Planning Application No: 3/2023/0854

Proposal: Proposed single storey side and rear extension and demolition of detached outbuilding. Resubmission of 3/2022/1073.

Location: 77 Ribchester Road Wilpshire BB1 9HT

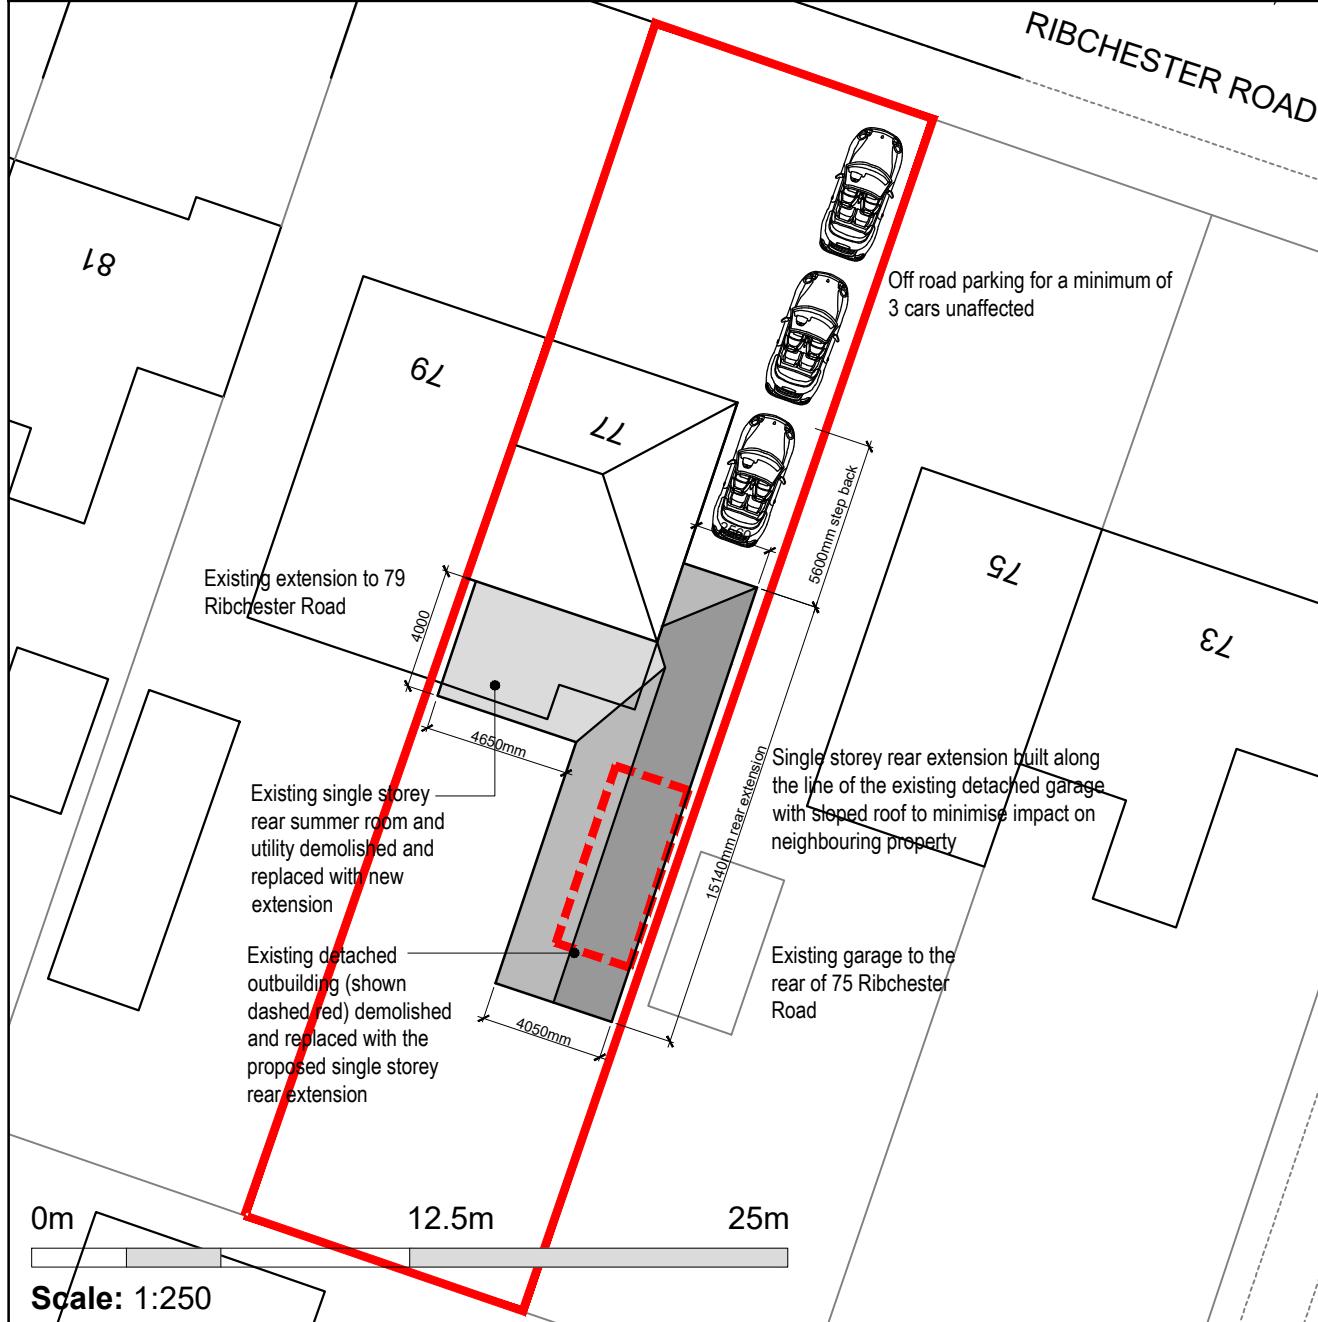
With reference to the Site block plan 1094/RRC/BP, Rev B Nov 2022, submitted; 'Off Road parking minimum of 3 cars unaffected', therefore no highway objection, as we are of the opinion that the proposed development should have a negligible impact on highway safety and highway capacity in the immediate vicinity of the site.
